Please ask for: Nicola Moore
Email: nicola.moore@arun.gov.uk
Telephone: Ext 37944
Our Ref: R/169/21/T
Your Ref:
Date: 8th July 2021

Application for Works to Trees(s) subject to a Tree Preservation Order(TPO)

Development: Fell 1 No Horse Chestnut tree
Location: 17 Walnut Avenue Rustington BN16 3NY

HORSE CHESTNUT (1)

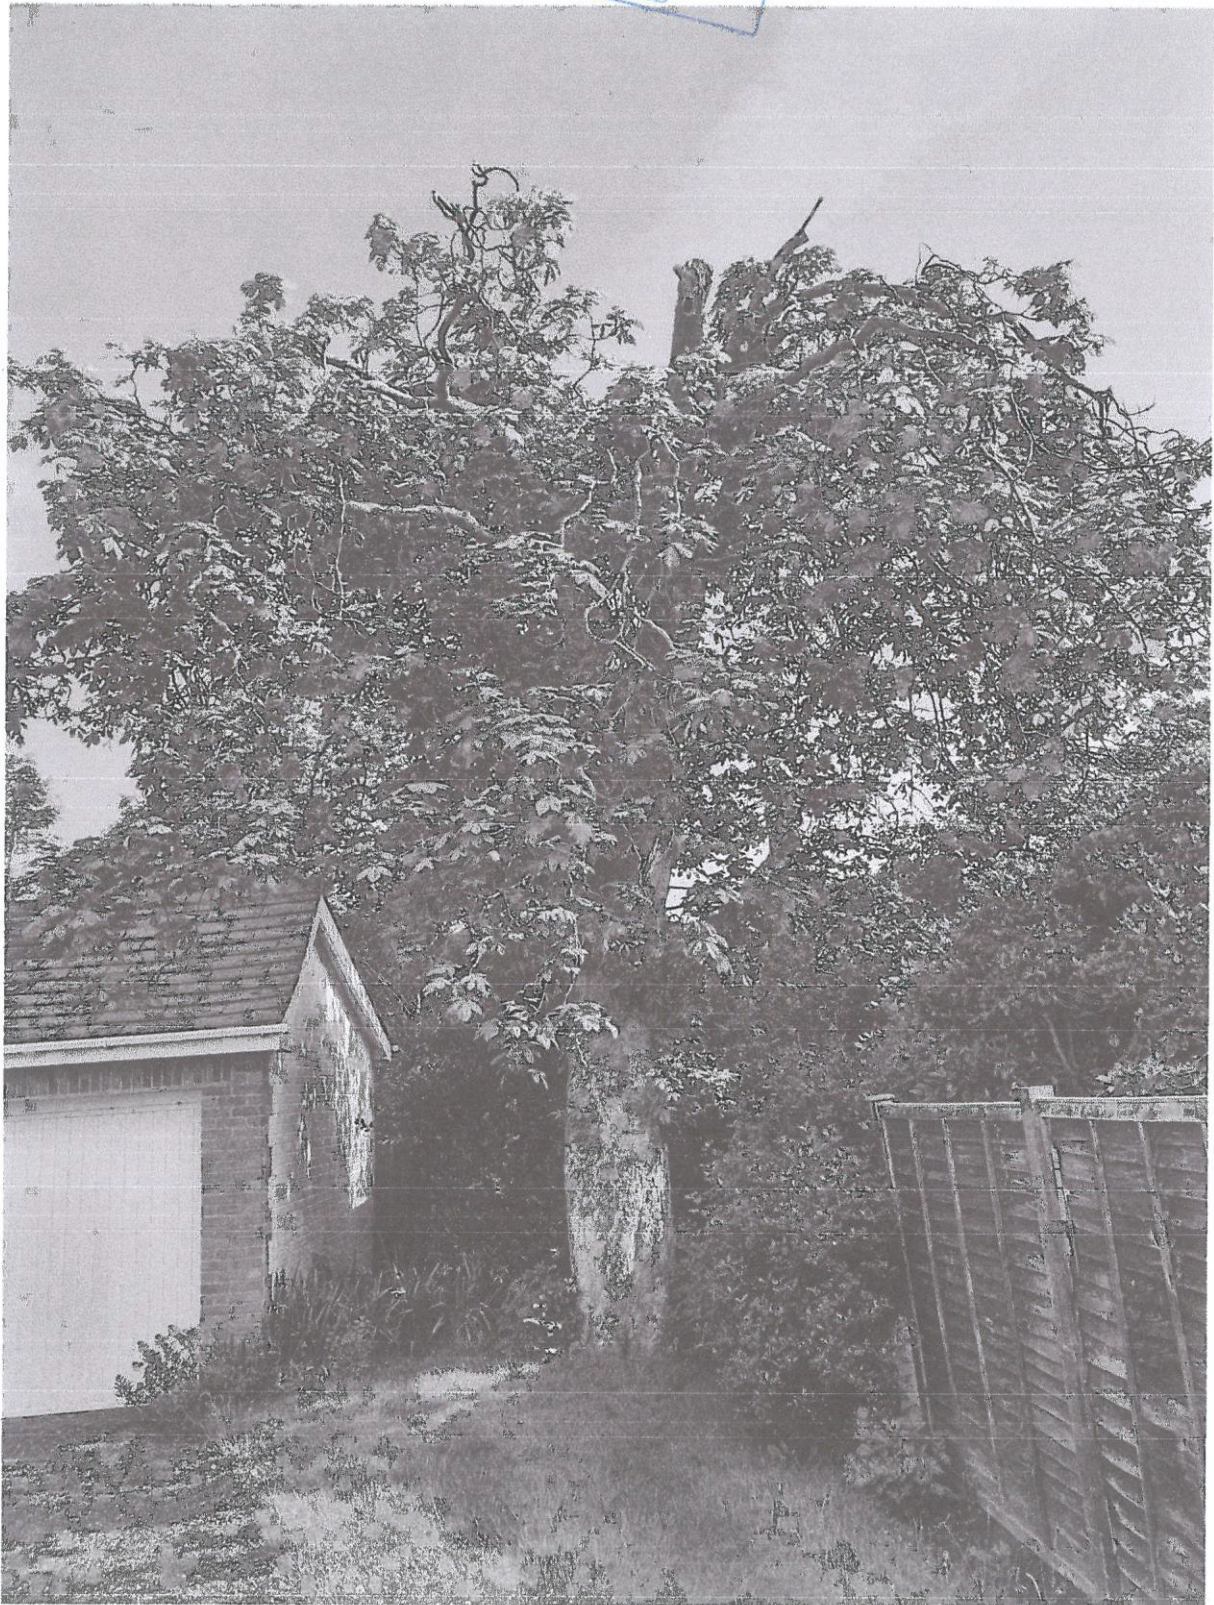
The sketch plan should include road names and adjoining properties. A north point is helpful. Please amend accordingly and re submit.
